# BENT GRASS EAST COMMERCIAL FILING 3

## EL PASO COUNTY, COLORADO PRELIMINARY PLAN TR BB BENT GRASS EAST COMMERCIAL NO 2B

## BENT GRASS EAST COMMERCIAL FILING 3 PRELIMINARY PLAN

8090 MERIDIAN PARK DR  
EL PASO COUNTY, CO

**TYPICAL PRIVATE ROAD CROSS SECTION**  
 SCALE: 1" = 10'  
 BENT GRASS MARKET VIEW  
 (PRIVATE ROADWAY)

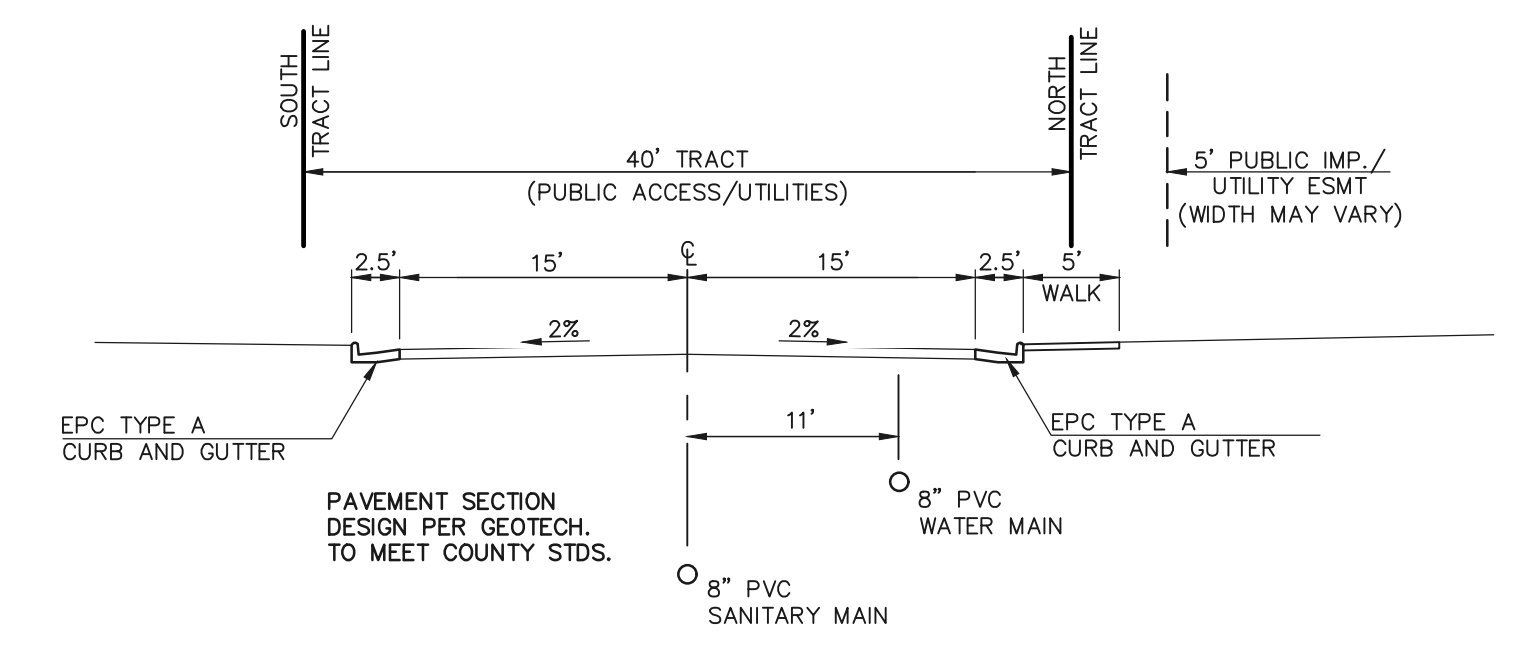
provide a cross section of the proposed private roadway. If the roadway will not be per County standards submit the appropriate deviation request.
